Town of Addison

Summary of Engineering Review Comments

Date: August 23, 2019
 Plan Review : Civil Review 1
 Received: July 30, 2019
 Plan Date: July 25, 2019
 Development: Galaxy FBO

Town Project #:19-09D

SHEET NUMBER
LP 1.01

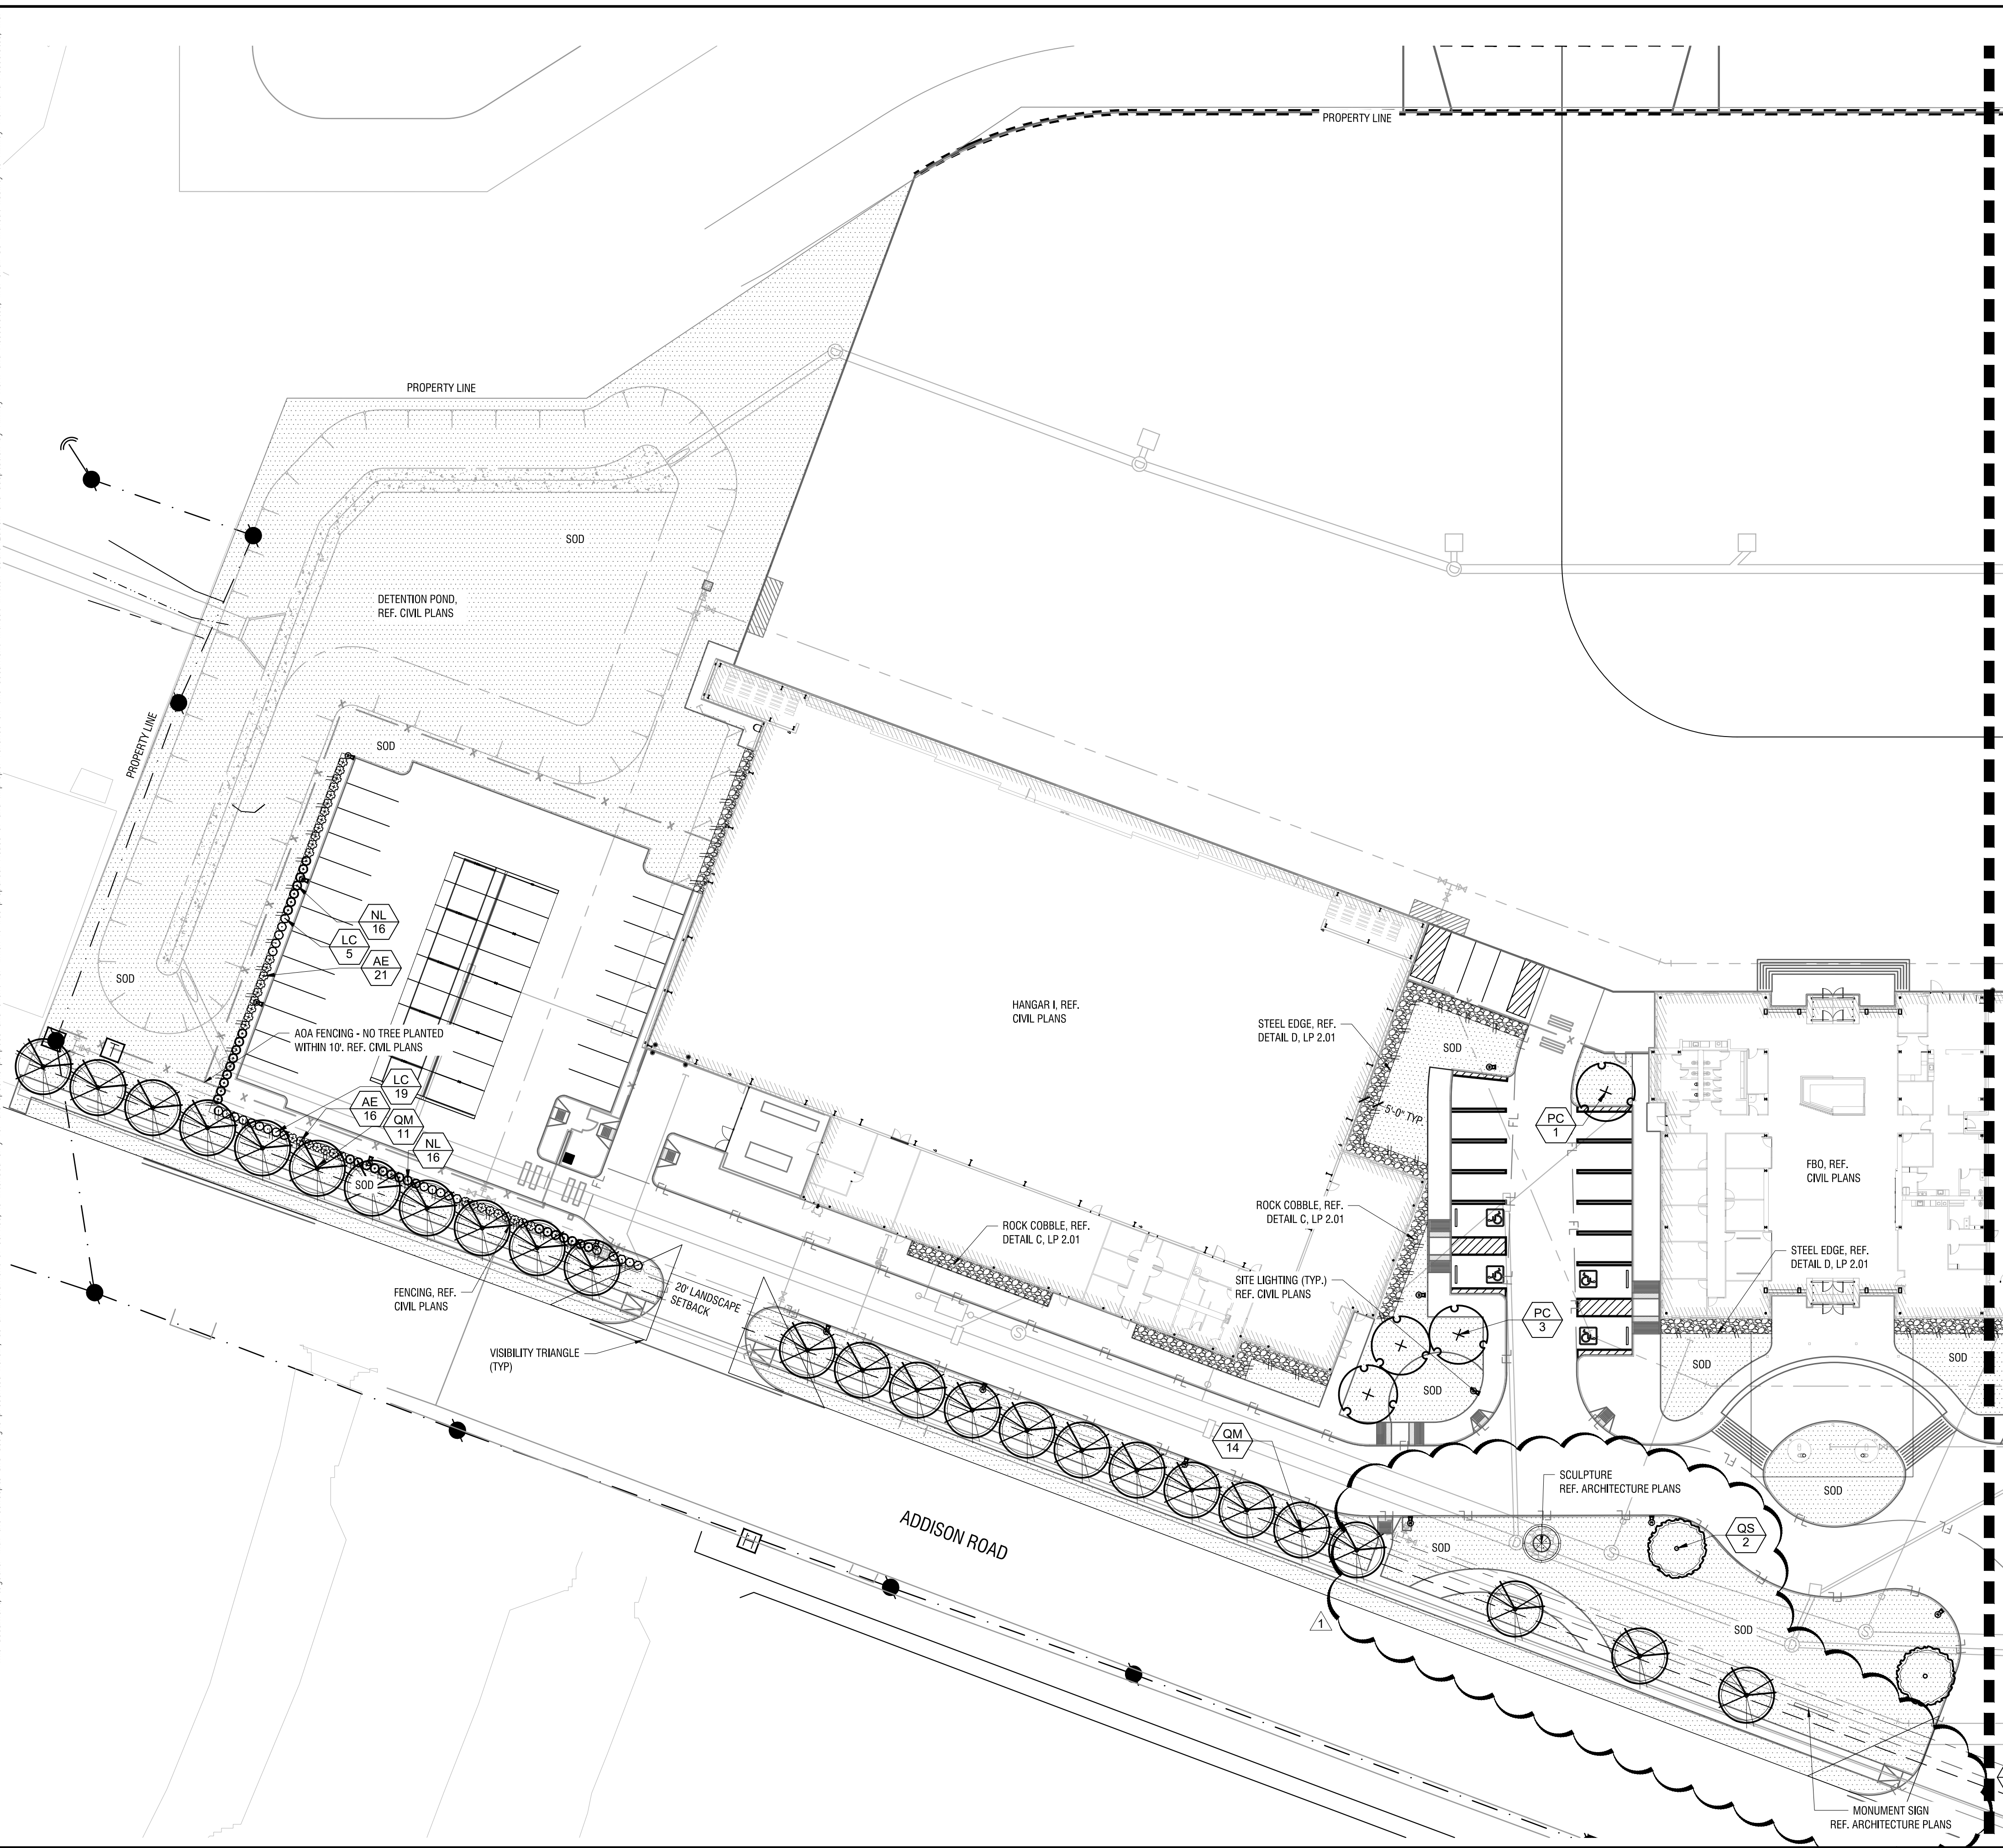
C17.02	Will the proposed AOA gate to the fuel farm be swing or slide?	AGREE	GATE IS TO SLIDE, SEE UPDATED LABEL
C17.04	Detail for swing gate?	AGREE	SEE SHEET C17.03
LANDSCAPE	Many proposed trees are too close to utility lines/appurtenances. Tree trunks should be a minimum of 8' from outside edge of utilities.	AGREE	
LANDSCAPE	Show concrete pads for FHA's/Valves/MH's/vaults, etc.	AGREE	
LP1.01	Include transportation visibility triangles (Fig 3.6), not just the landscape triangles.	AGREE	SEE ATTACHED SIGHT VISIBILITY TRIANGLE EXHIBIT
LP1.01	No seeding. Sod.	AGREE

Page No.	Comments	Response (See Note)	Explanation
LP1.01	Include re-establishment of newly graded/re-graded areas south of site.	DISAGREE	SEE CIVIL PLANS FOR NEWLY GRADED/RE-GRADED AREAS TO THE SOUTH OF THE SITE.
LP1.02	Discuss possibility of moving water line further west and trees further east (see markups) with civil eng in order to keep trees on either side of the fuel farm access.	AGREE

SHEET NUMBER  
**C13.02**

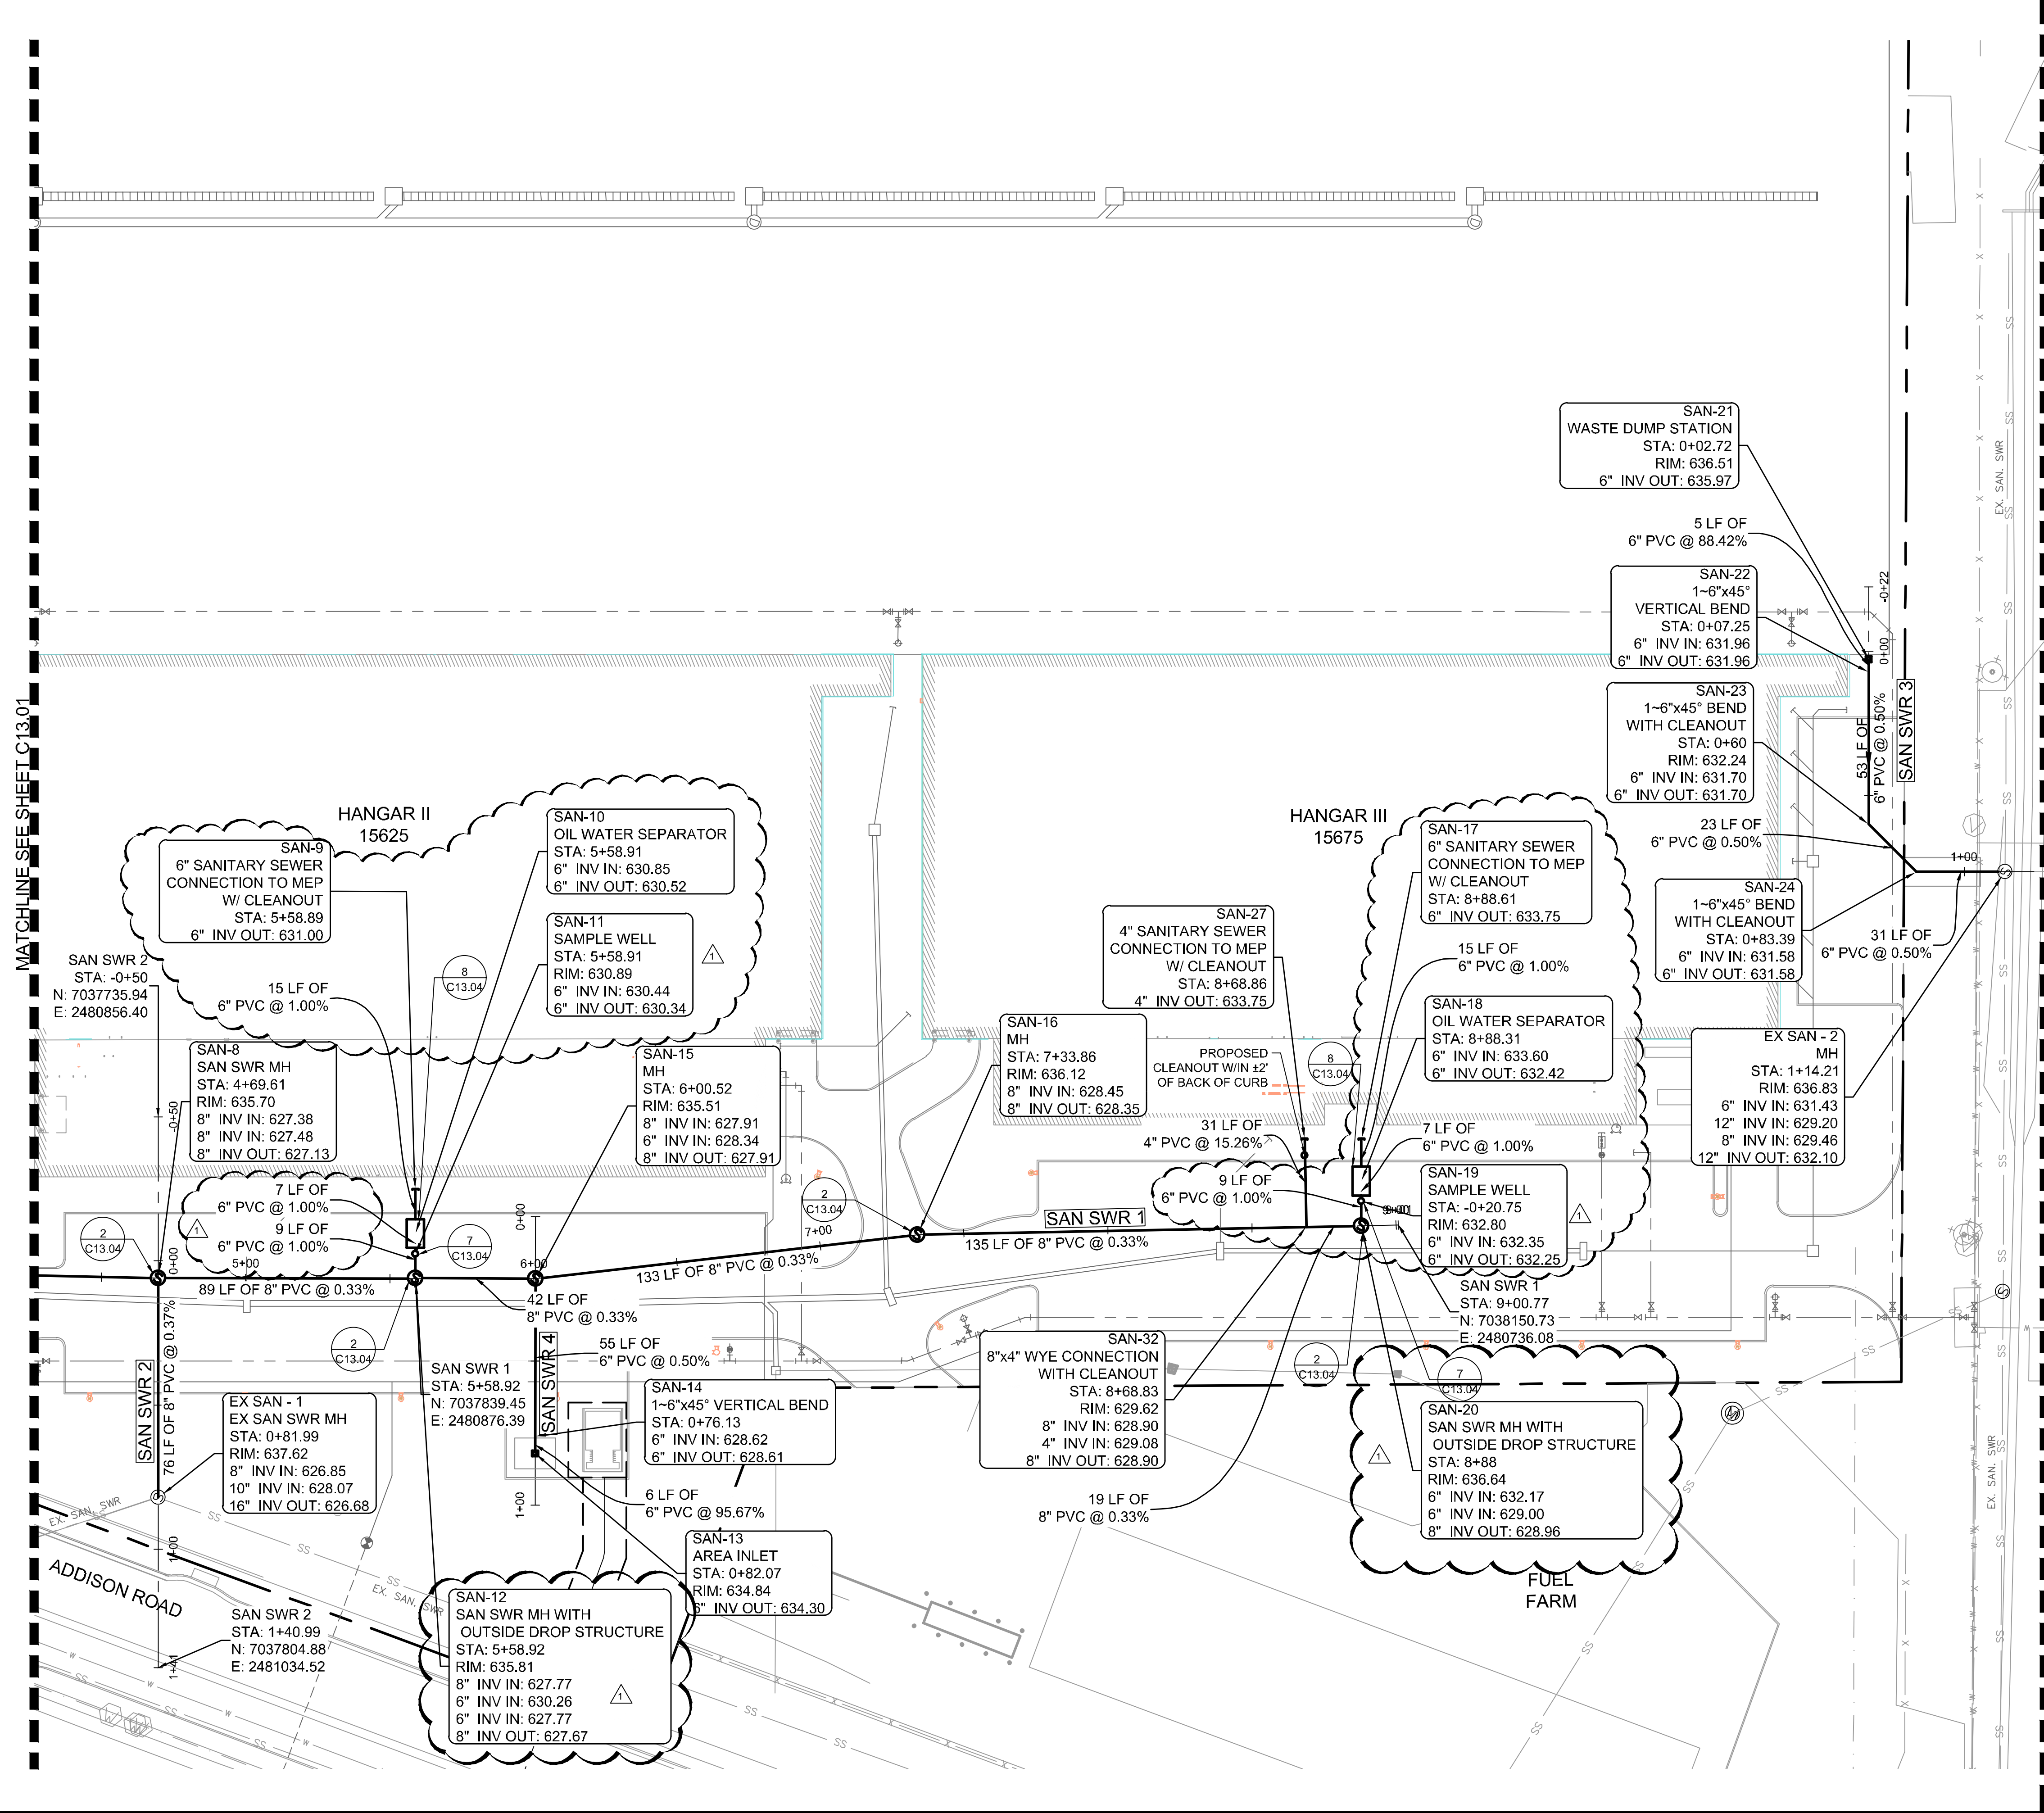
C13.01	Cleanouts at all bldg connections	DISAGREE	THE CLEANOUTS AT THE BUILDINGS ARE TO BE DETERMINED BY THE MEP
C13.02	Would like SAN-16 MH moved into drive & outside of the landscape island	AGREE	
C13.02	Profile the dumpster service & show encasement where it crosses the water	AGREE

Page No.	Comments	Response (See Note)	Explanation
C13.02	Show & profile the new service that will be required for the discharge from the fuel farm oil/water separator, encase it where it crosses the water.	AGREE	PER THE EMAIL ATTACHED TO THIS SUMMARY OF REVIEW COMMENTS FROM JENNY PRAZAK WITH COBB FENDLEY, THE EXISTING OIL/WATER SEPARATOR ON THE FUEL FARM SITE WILL CONTINUE TO DISCHARGE INTO THE STORM SEWER RUNNING THROUGH THE SUBJECT SITE. SINCE THERE IS AN EXISTING PUBLIC SANITARY SEWER LINE RUNNING ALONG THE WEST SIDE OF THE ADDISON ROAD RIGHT OF WAY (I.E. ADJACENT TO THE FUEL FARM SITE) WE ARE NO LONGER PROPOSING A SANITARY SEWER STUB TO THE BOUNDARY OF THE FUEL FARM SITE FROM WITHIN THE SUBJECT SITE. IN THE FUTURE, IF THE AIRPORT AND/OR TOWN DETERMINE THE OIL/WATER SEPARATOR ON THE FUEL FARM SITE NEEDS TO DISCHARGE TO SANITARY SEWER, THE EXISTING PUBLIC LINE ON THE WEST SIDE ADDISON ROAD PROVIDES A CONNECTION POINT.

C13.02	6" service connections require manholes @ main, not tees/wyes.	AGREE	
C13.02	Car wash drains should be connected to sanitary sewer (b/c of soap/detergents), & should have oil/water separator (check with TOA Environmental Services & plumbing codes to confirm). If allowed to discharge to storm, will need another stormwater interceptor on the eastern trunk line downstream of the car wash lateral.	AGREE	
C13.02	What is being dumped at the waste station at SAN-21? Does it need an oil/water separator also?	DISAGREE	THAT IS JUST A NORMAL SS WASTE, AN OIL/WATER SEPARATOR IS NOT NEEDED
C13.02	Put cleanouts at bends.	AGREE
